From: Hutton, Laura-Beth [<mailto:Laura-bethHutton@eversheds-sutherland.com>]
Sent: 17 December 2018 15:05
To: Ewa Sherman; Northampton Gateway
Cc: Thomson, Morag; Kate Mignano
Subject: Northampton Gateway - ISH3 - Applicant's Responses to ExA Queries
Importance: High

THE NORTHAMPTON GATEWAY RAIL FREIGHT INTERCHANGE ORDER 201X
APPLICANT'S RESPONSES TO ExA QUESTIONS IN TABLE TO ISH3 AGENDA

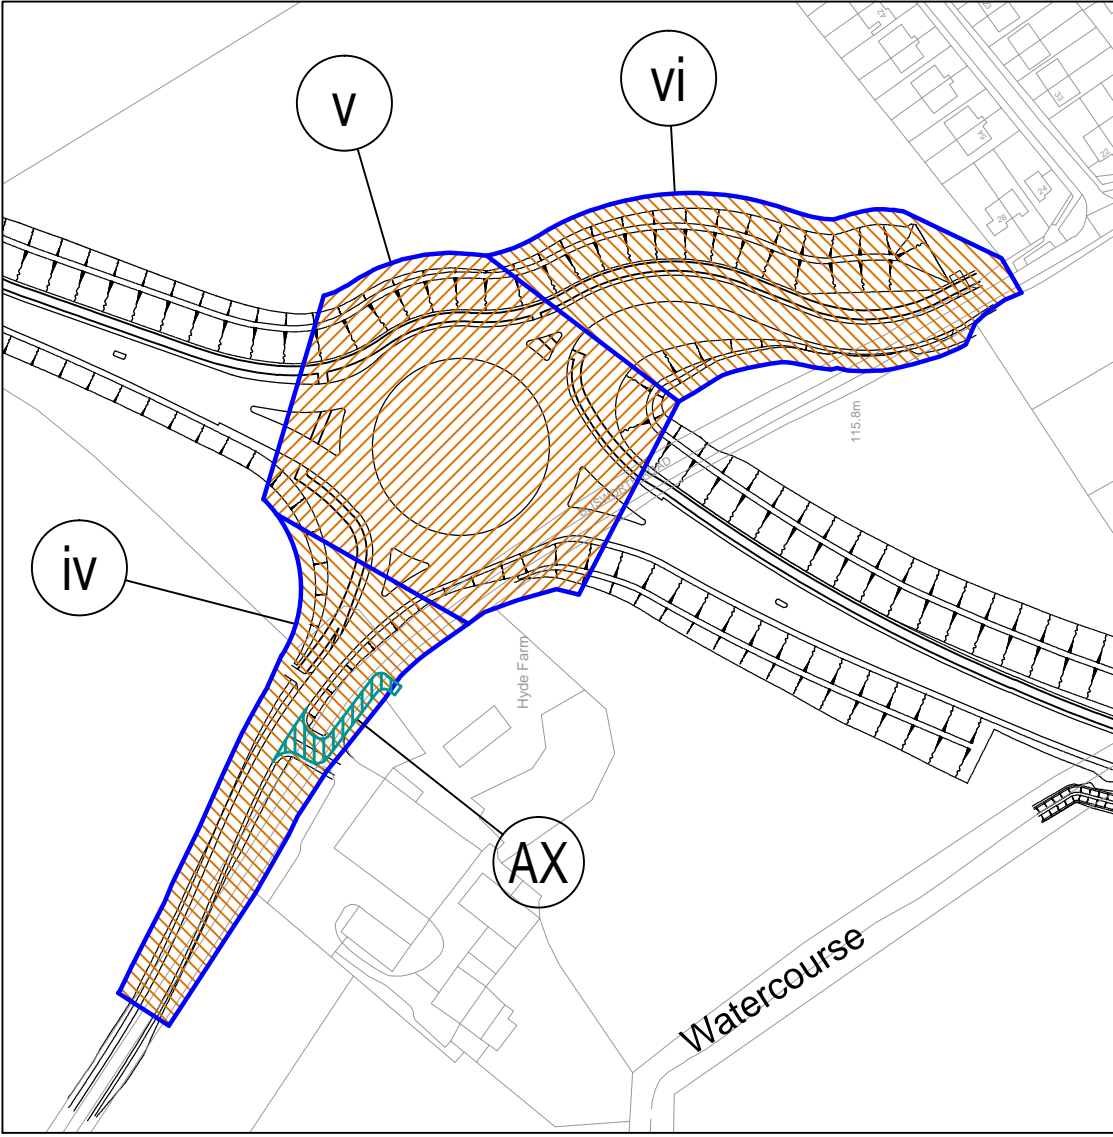
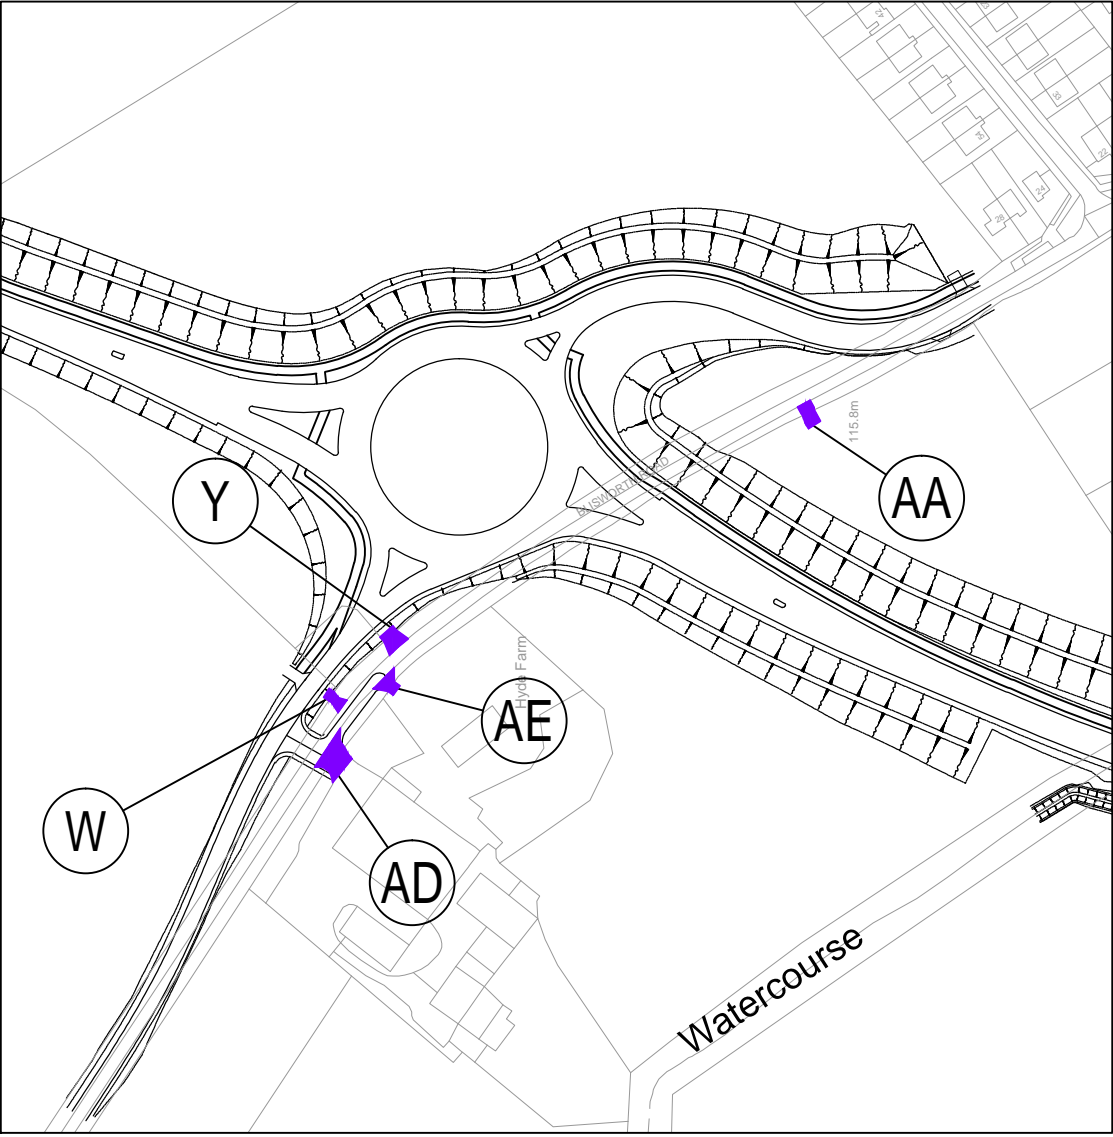
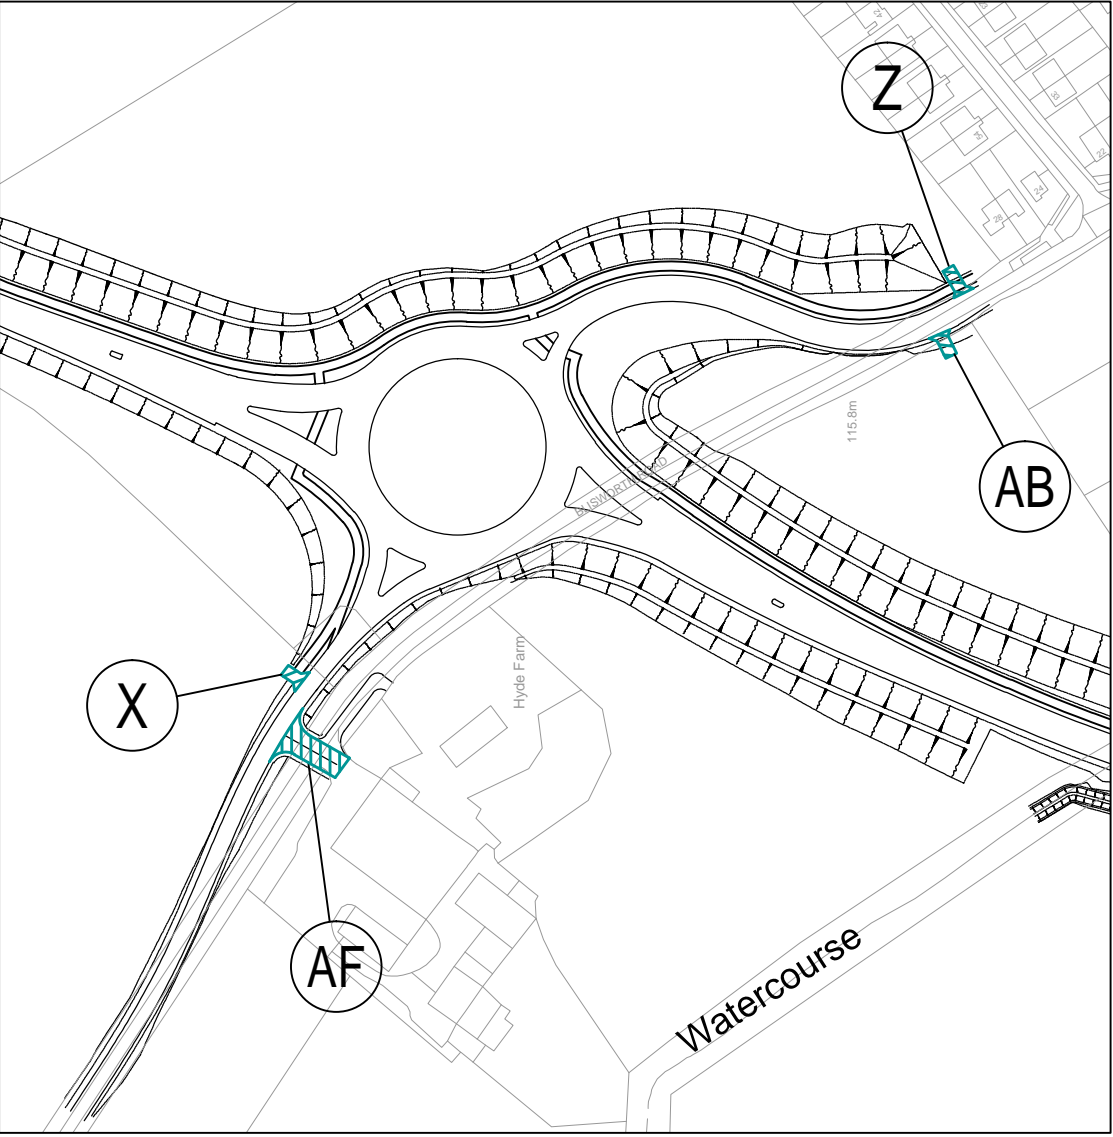
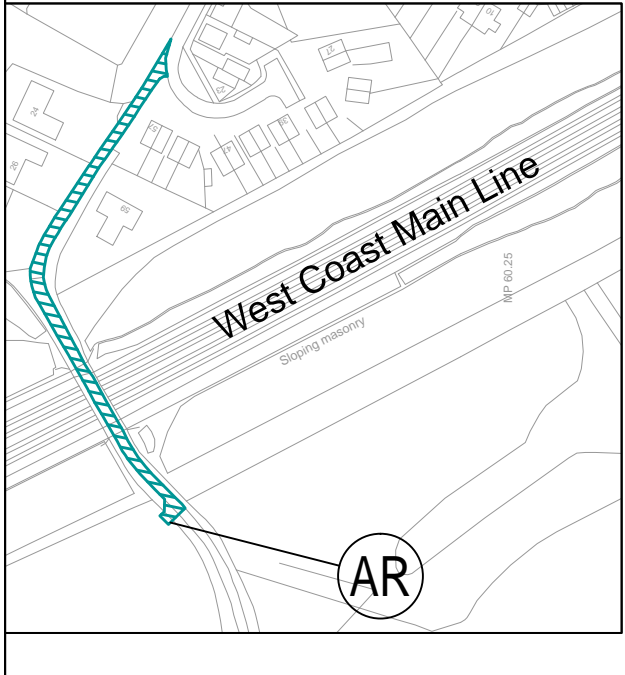
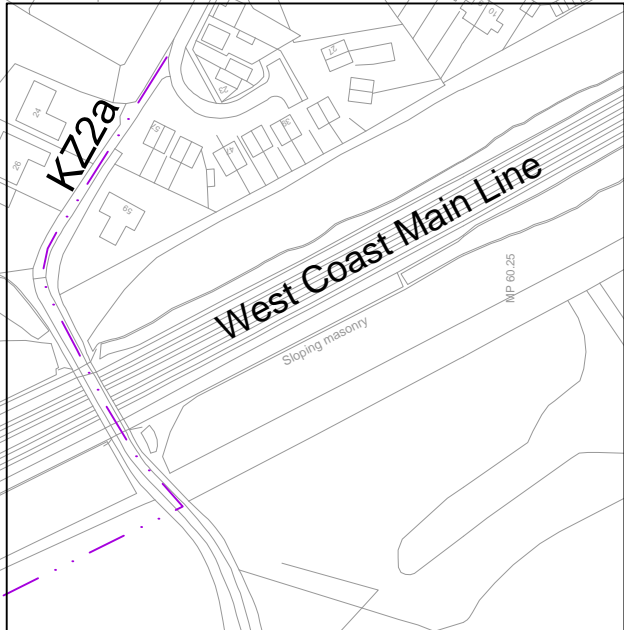
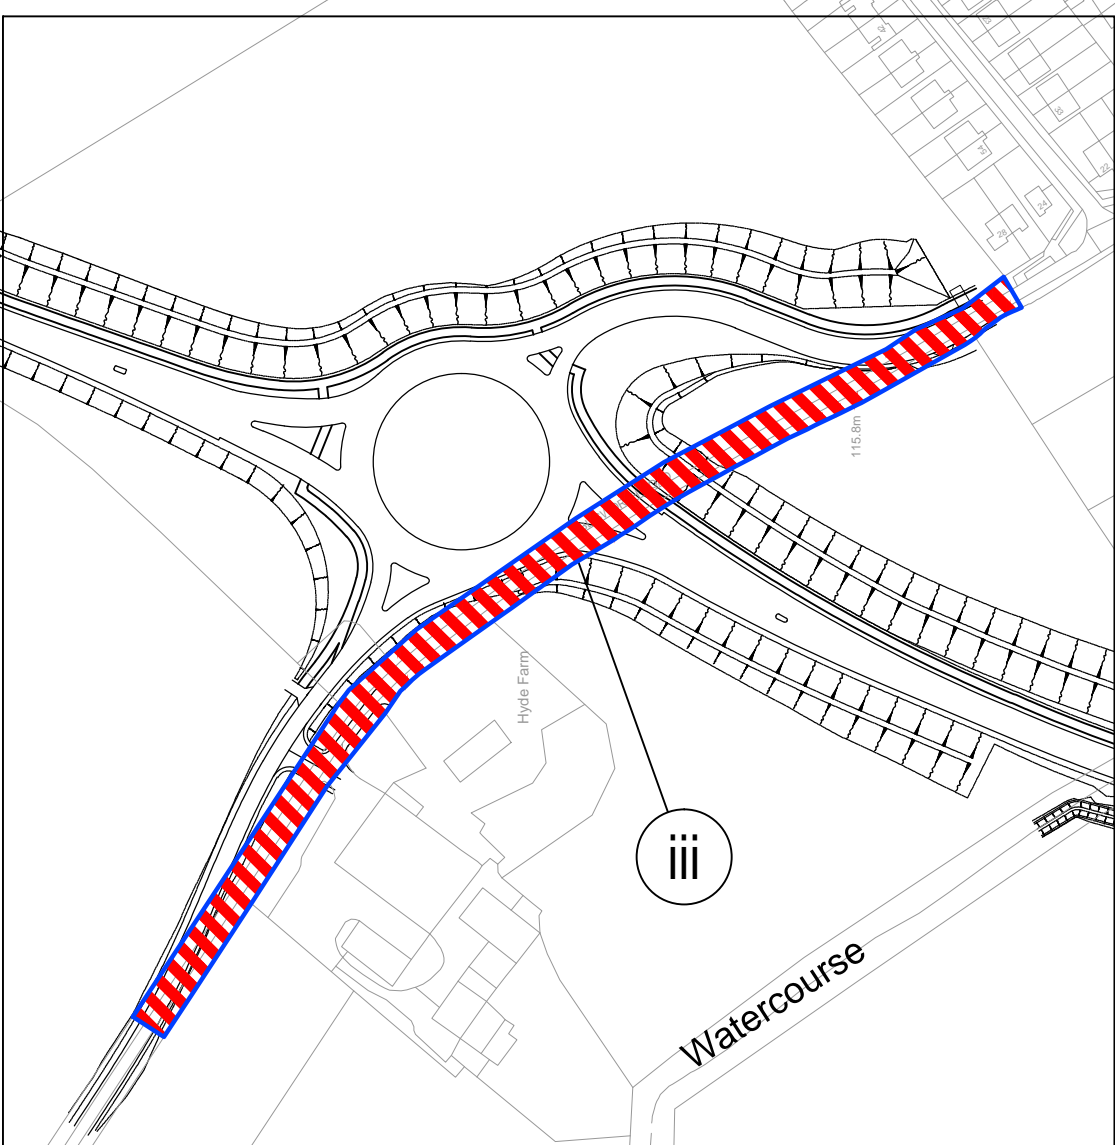
5	NCC	Art 10 and Sch 4 Column	A508 highway; The three stoppings up at	The three stoppings up at the Rookery Lane/ Ashton Road/ A506 jn (x, xii and xiv	This should refer to the A508 rather than A506.

2	<i>the Rookery Lane/ Ashton Road/ A506 jn (x, xii and xiv on Doc 2.3E [APP-025])</i>	on Doc 2.3E [APP-025] are replaced by a new junction in three separated parts (xi, xiii, and xv), one for each of the stoppings up. When combined they appear to be an alternative. But taken separately they would be inadequate. For example if the portion of Rookery Lane to be stopped up, which is currently the mouth of the junction with the A506, was only replaced by the corresponding new highway it would not reach the A506 because the new part of the A506 is located further east. The stopped up part of Rookery Lane is marked xii and the alternative is marked xiii on Inset 5C. Is not something needed on sequencing to enable the SoS to be satisfied that there will be an alternative? If so, please could the Applicant provide suitable drafting?	<p>There is no intention to implement the stopping up referred to in part resulting in a new road ending in a field. This is dealt with in the protective provisions dealing with the carrying out of the County Highway Works.</p> <p>Paragraph 3(1) of Part 3 of Schedule 13 provides that no work can be carried out on any Phase until both the Detailed Design Information and a Programme of Works has been agreed for that Phase. Programme of Works is defined as “a document setting out the sequence and timetabling of the Phase in question”.</p> <p>Paragraph 4(3)(c) requires that the works be carried out in accordance with the approved programme.</p> <p>It would clearly not be acceptable to provide a programme for approval that sought to stop up and substitute one section of road that is then not connected into the wider road network.</p>

6	NCC, Messrs AW, W & R Irlam	Art 10 and Sch 4 Column 2	<i>A508 highway The three stoppings up at the Rookery Lane/ Ashton</i>	The Relevant Representation from Berrys on behalf of AW, W & R Irlam says this: “The current layout [of the junction]	The Applicant does not propose to

<p>Road/ A506 jn (x, xii and xiv on Doc 2.3E [APP-025])</p>	<p>facilitates tractors with cultivators, long combine harvester headers, etc., to swiftly across [sic] the junction without any road furniture/ structures impeding the route. The revised layout includes a central island which will impede or possibly even prevent agricultural vehicles swiftly and safely crossing. ...</p> <p>The conclusion is that if the DCO is granted then it must incorporate a further revision to the road layout at this junction to ensure the on-going safety of large vehicles including agricultural machinery. Any change to junction layout must also minimise land taken from agricultural production.”</p> <p>Does the Applicant propose any redesign of the junction? If so, how?</p> <p>Does this representation go to the question of whether the stopping up can be approved at all, because of the design of the alternative? Or does it go to the question of whether the adverse impact of the NSIP would outweigh the benefits, rather than to whether there is an alternative highway? Or does it go to something else, and if so, to what?</p>	<p>amend the design of the junction from that submitted. The Applicant has provided a detailed response to this point in the response to the Relevant Representations (Document 8.3, REP1-022) ref RR-789 and can confirm that the layout has been agreed with Northamptonshire County Council.</p> <p>The proposed scheme provides significant improvements to visibility (as confirmed in the A508 Geometric Design Strategy Record, which is Appendix 29 of the Transport Assessment (TA), the TA being Appendix 12.1 of the Environmental Statement, Document 5.2) and removes the crossroads, replacing it with a staggered crossroads. Furthermore the tight bend to the south will be removed.</p> <p>The Applicant appreciates that the layout needs to accommodate the needs of large agricultural vehicles. Analysis of the tracking of large agricultural vehicles has been undertaken using vehicle information supplied by Messrs Irlam. This demonstrates that the proposed layout will not prevent such large vehicles from crossing from Rookery Lane onto Ashton Road and vice versa. This has been shared with</p>

<p>Northamptonshire County Council who have confirmed that the proposals are acceptable given the occasional use and such movements are by no means unusual on the rural road network.</p> <p>Whilst a road safety audit has already been undertaken on the proposed layout, the detailed design will be subject to a second road safety audit in due course – followed by further audits following completion of the works.</p> <p>The Applicant believes the representation simply refers to the previous preference that no works be undertaken to this junction. The Applicant further understands that Messrs Irlam now agree with the proposal.</p>
7	NCC	11	<i>Temporary stopping up of streets</i>	<p>Please can the Applicant explain how these temporary stoppings up relate to the development or to matters ancillary to the development (bearing in mind the words of s120(3) of PA 2008); or give some other power for the SoS to include Art 11.</p>	<p>As identified in Document 8.1 (REP1-019), the article is derived from the model provisions and is included in most DCOs. The article includes suitable protections for users of the streets and allows conditions to be attached to any consent issued by the relevant highway authority.</p> <p>The Applicant considers that the power is related to the various highway works included in the</p>
